Application for removal or variation of a condition following grant of
planning permission. Town and Country Planning Act 1990.
Planning (Listed Buildings and Conservation Areas) Act 1990

Approval of reserved matters (access, appearance, landscaping, layout and scale) following outline permission Y/19/16/OUT for 108 residential dwellings, with associated parking, road/footway/cycleway provision, open space, landscaping, surface water attenuation and ancillary works.

Y/98/18/RES

Drawing no: 18.1330.606 Rev: C3

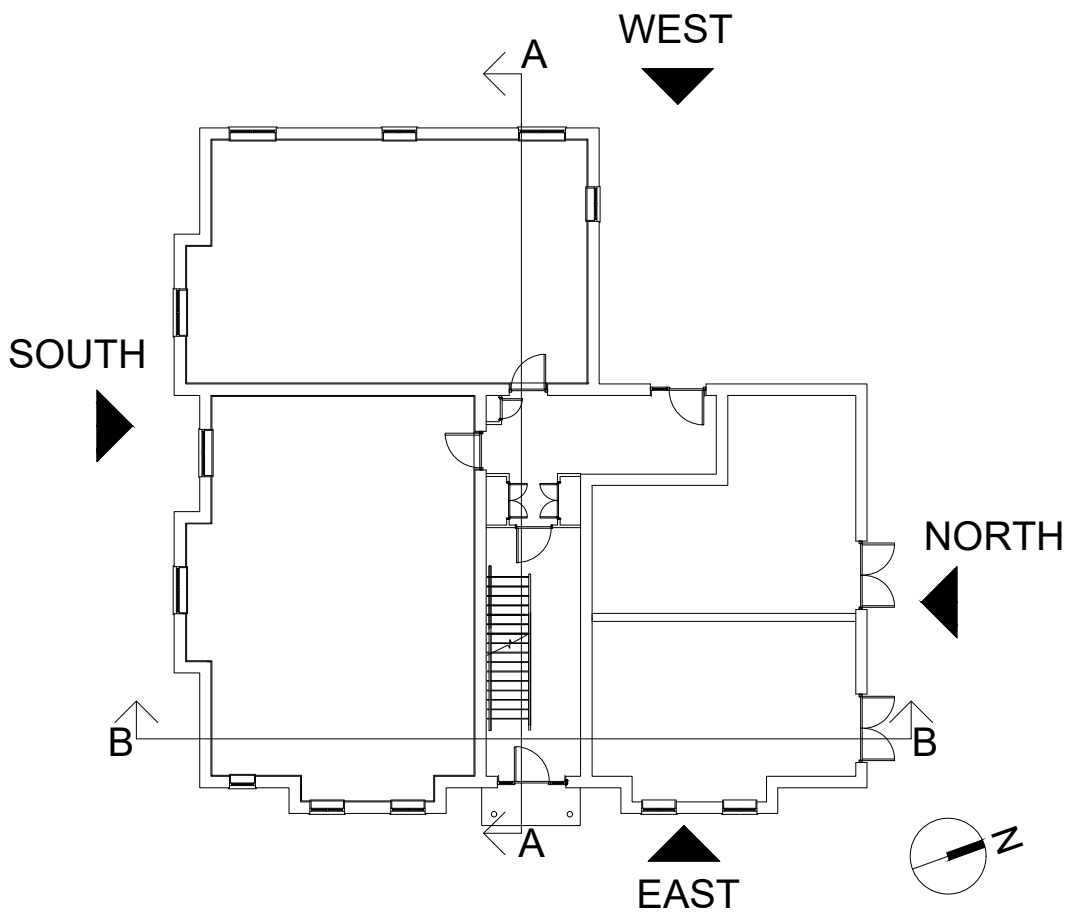
-The OV has changed from two units to one larger unit. Shown on the east elevation of drawing 18.1330.606 in the roof space.

Drawing no: 18.1330.701
Rev: C2

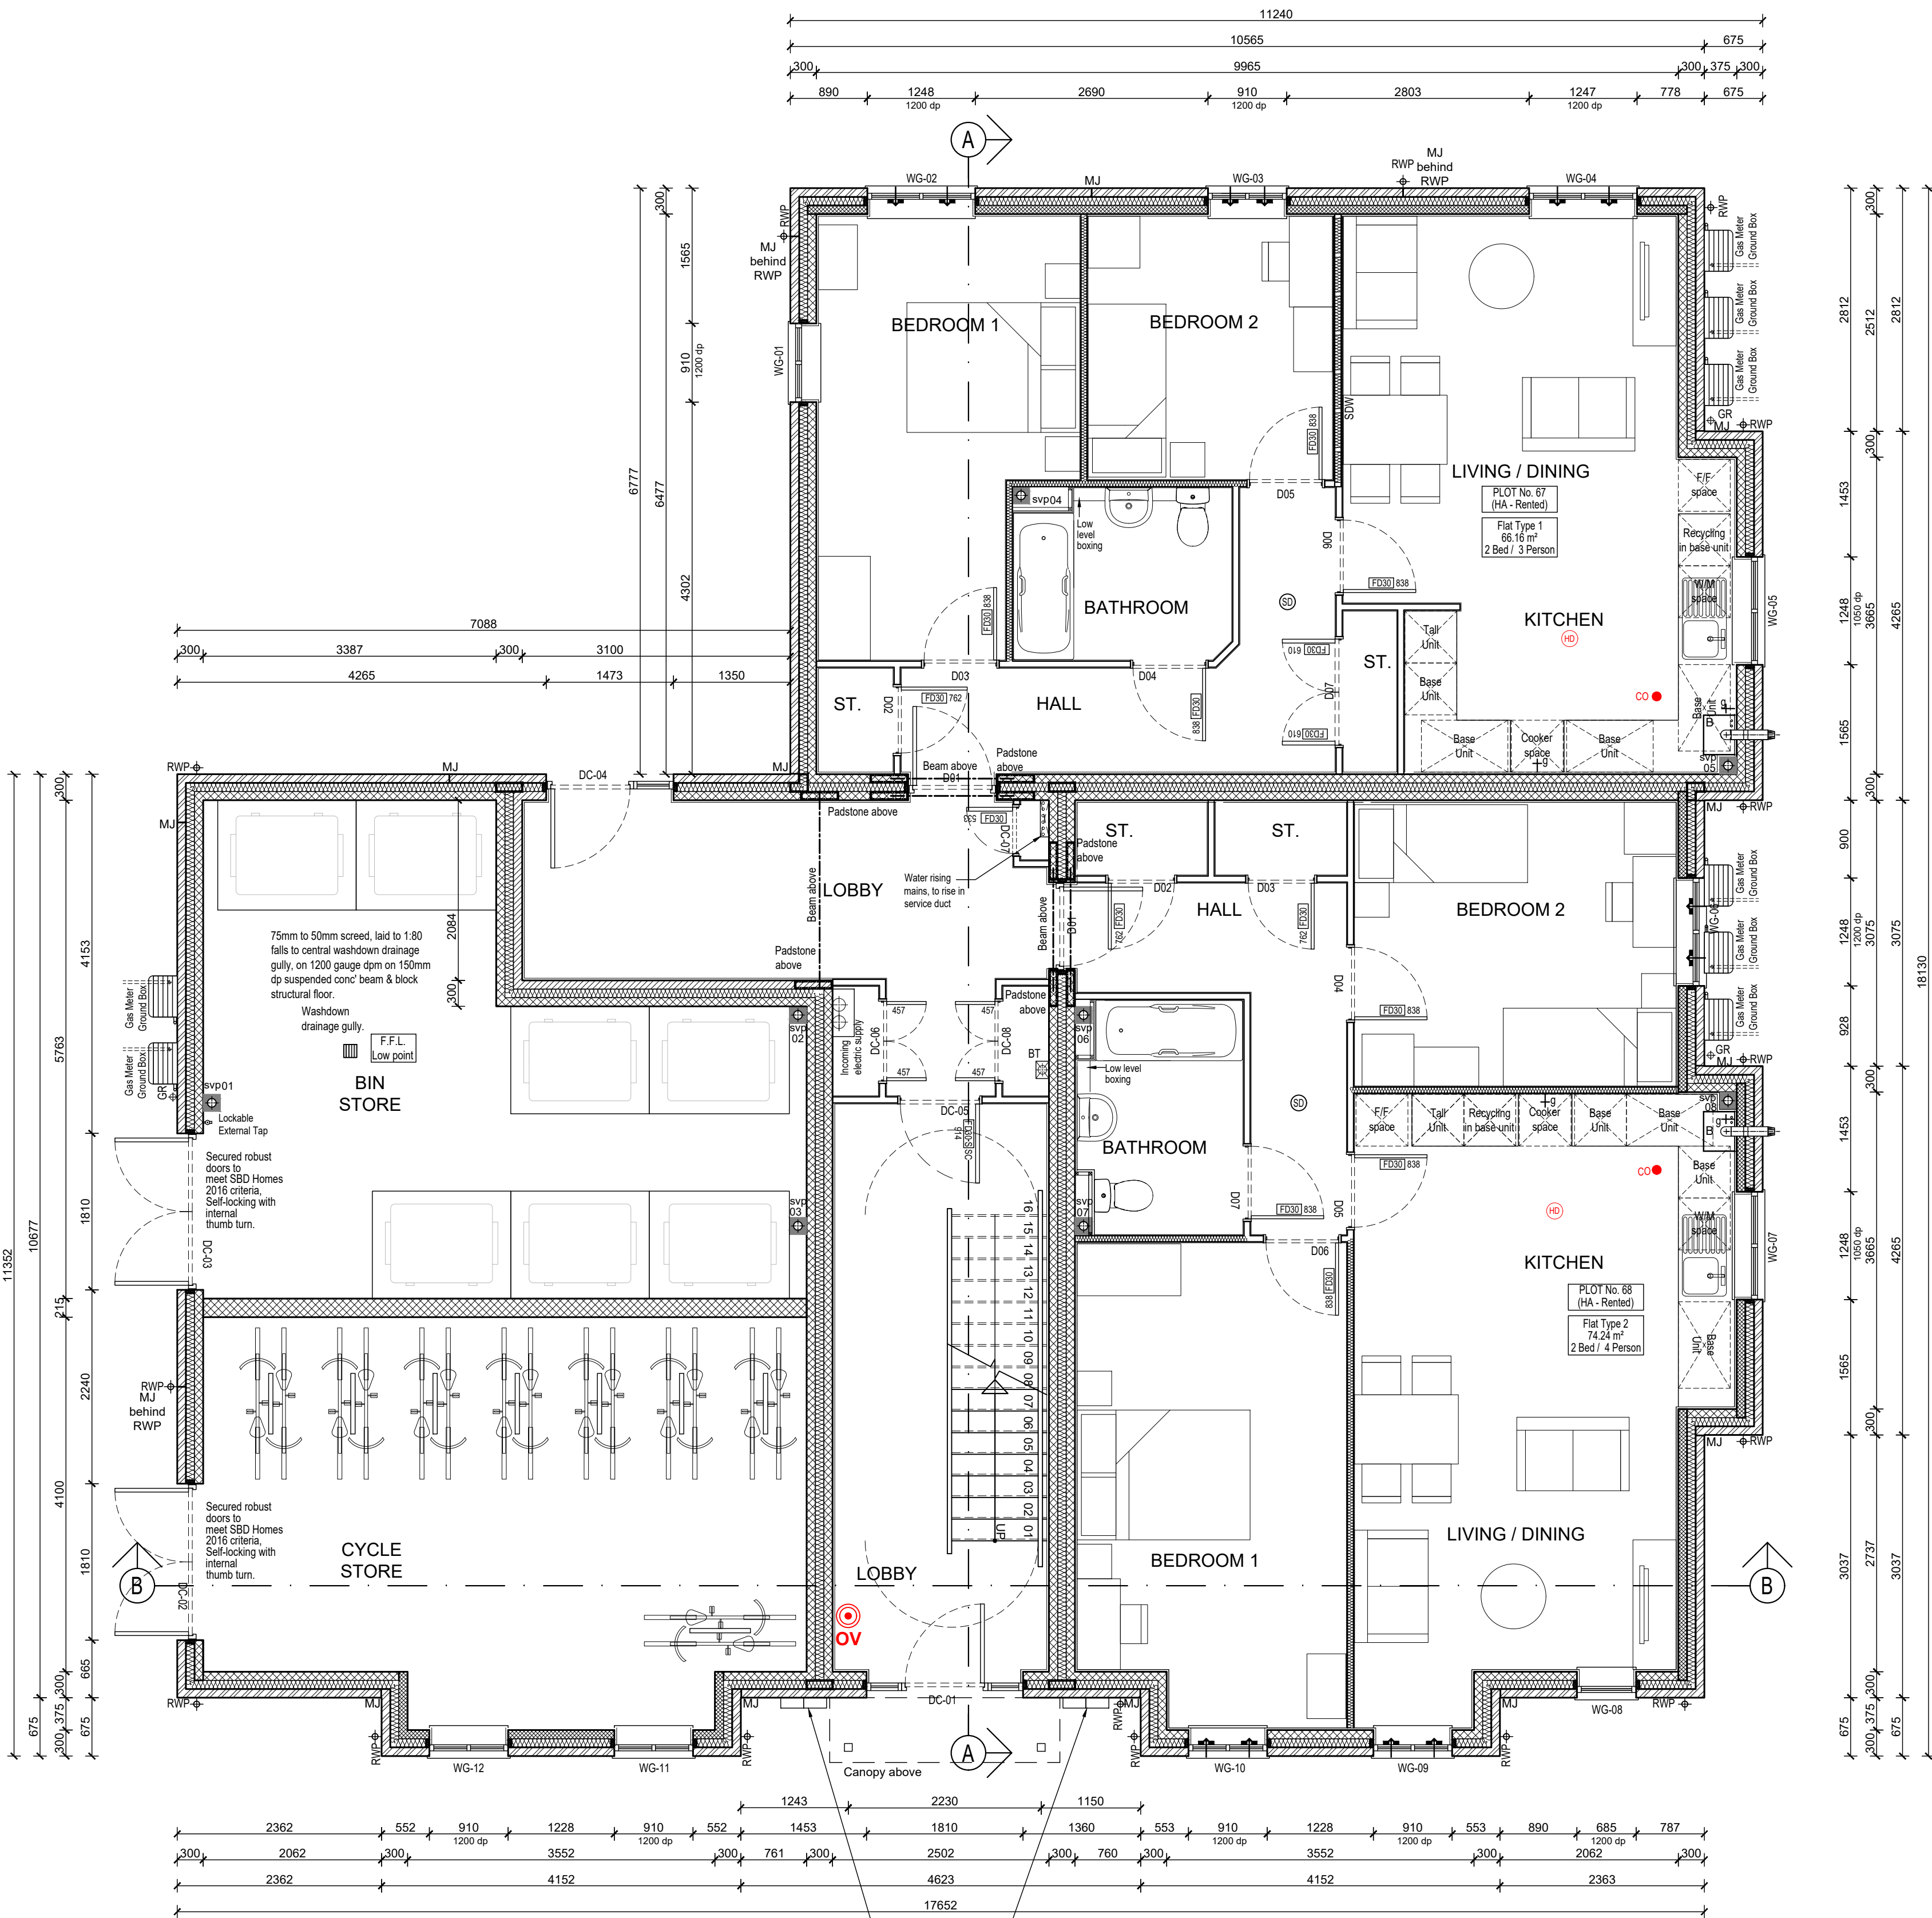
-Apartment changes for 67-74 on the south side of elevation drawing 18.1330.706. The window configuration has changed to suit the revised kitchen layout internally. It did not meet the minimum required volume capacity set out in the HQI standards at the planning stage.

Drawing no: **18.1330.704** Rev: **C3**

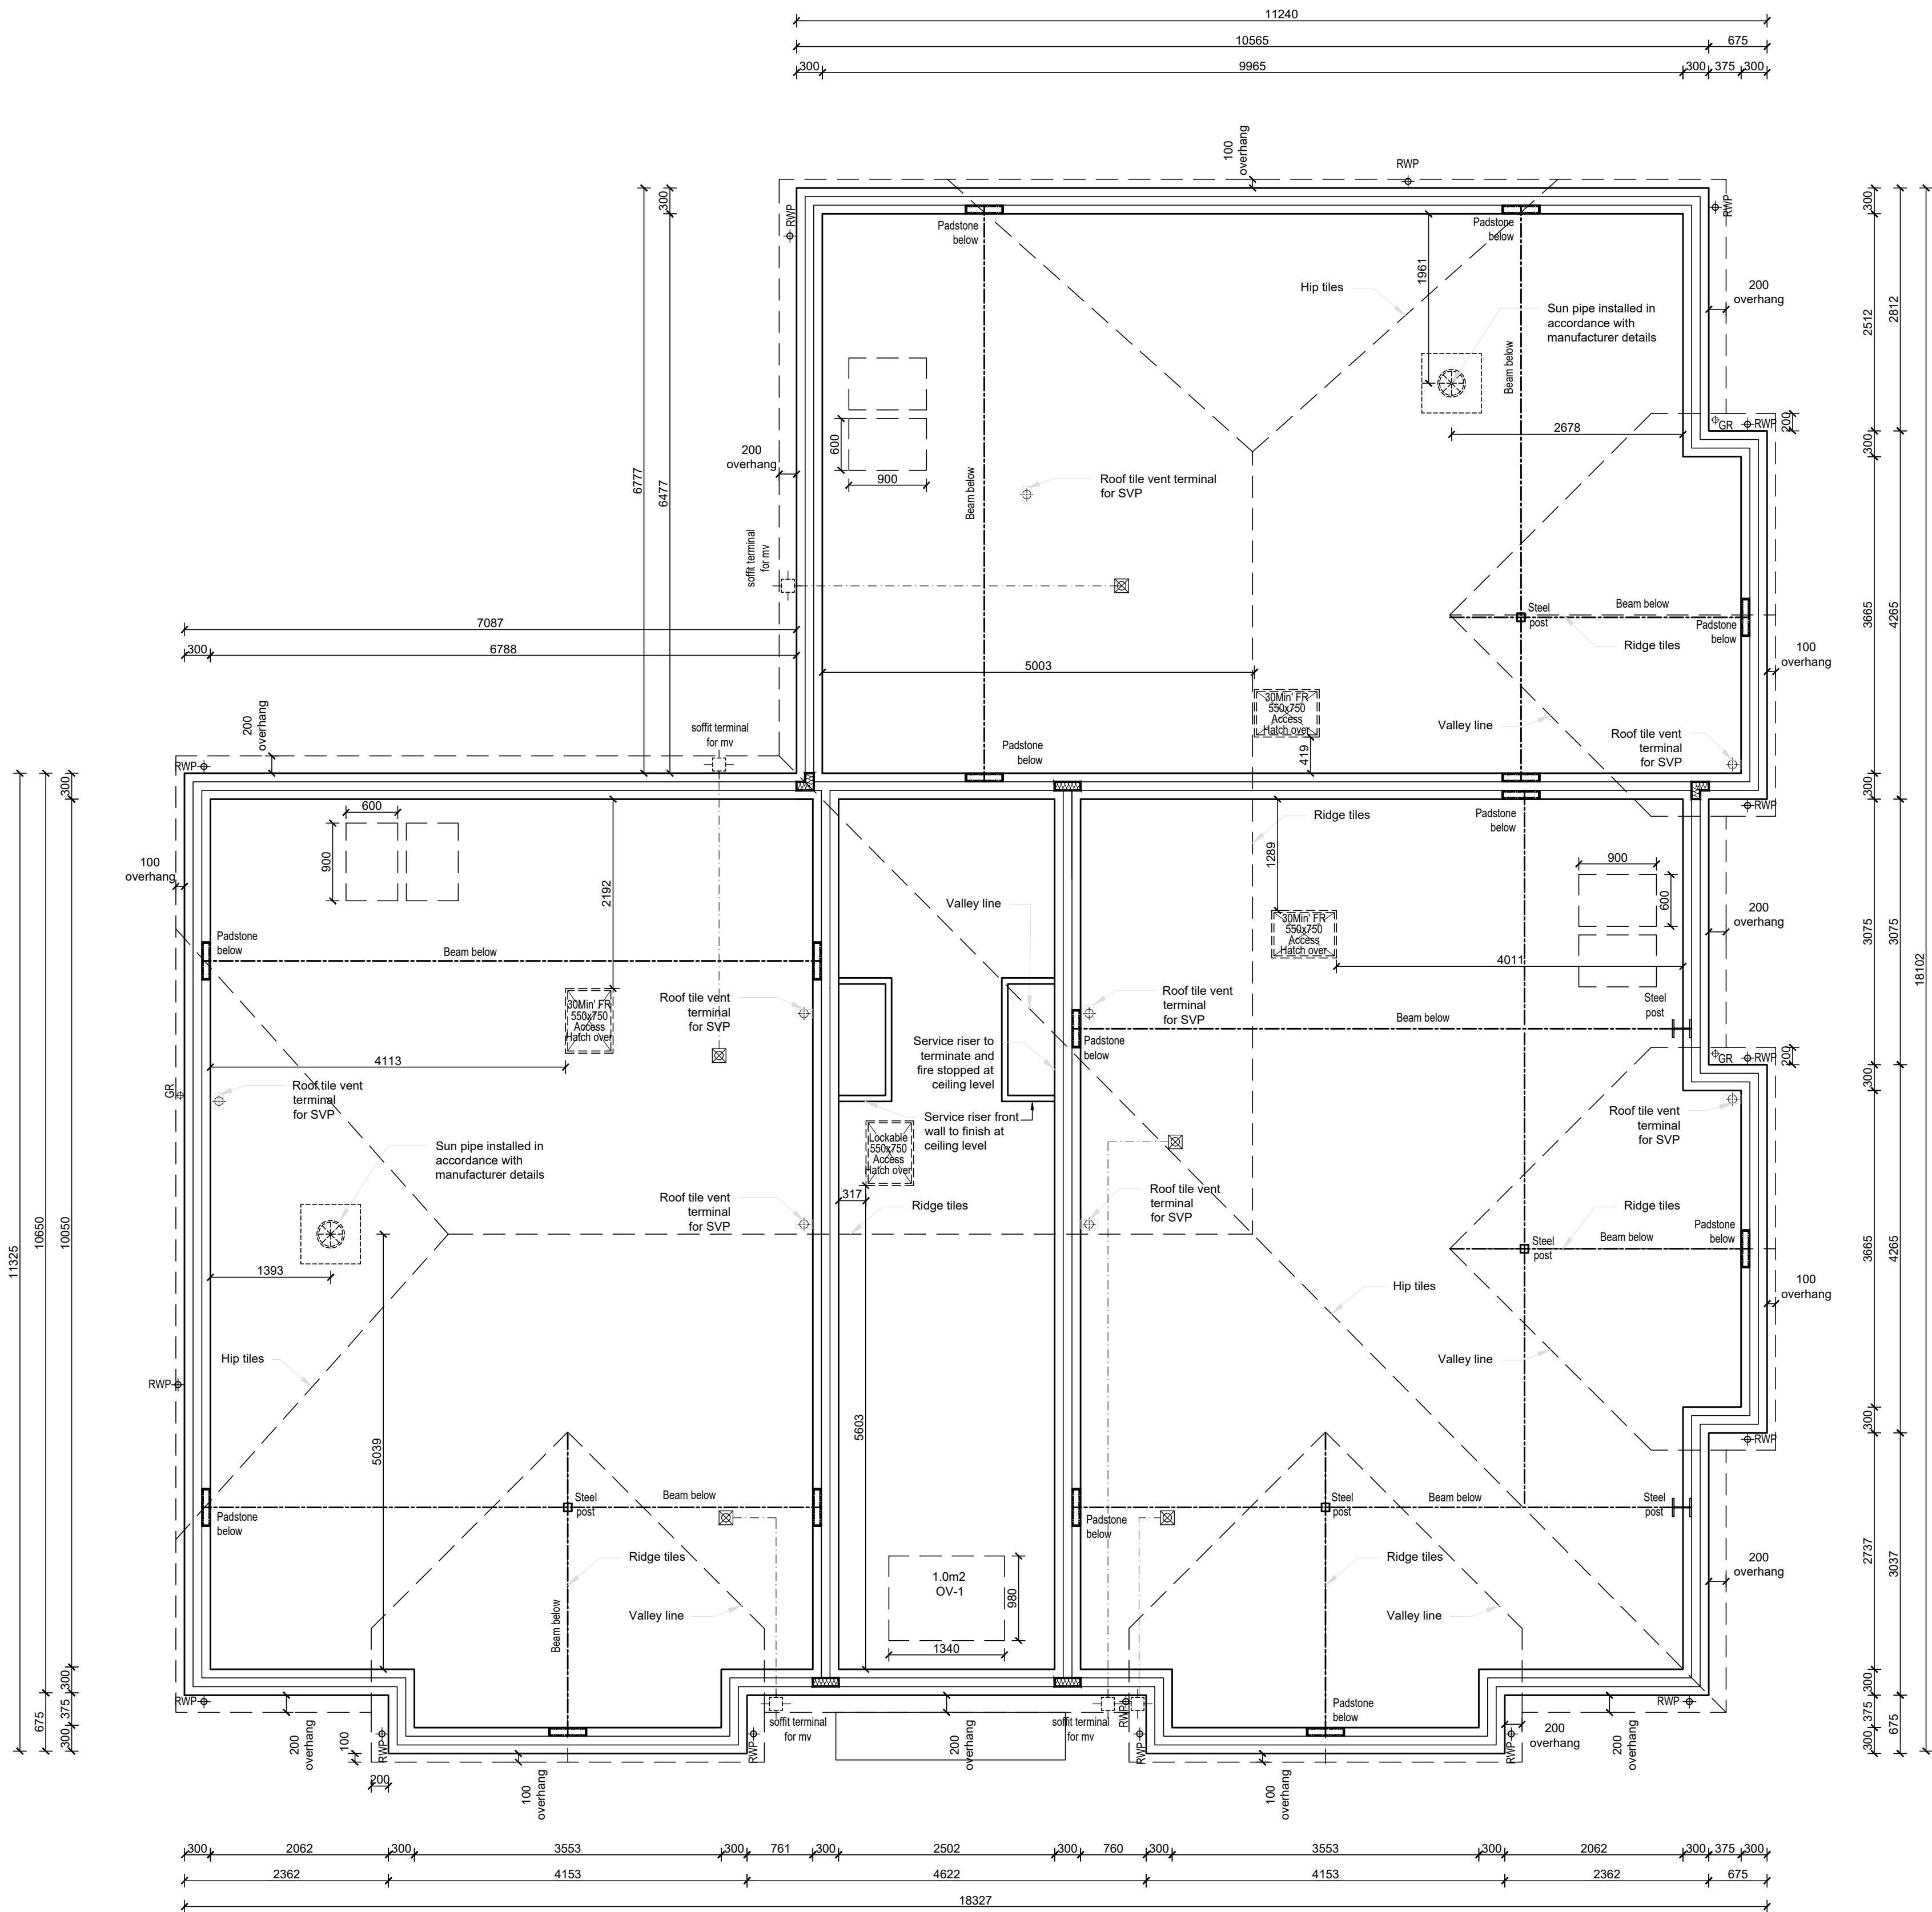
-Sun Tubes added for plots 62,63,73,72
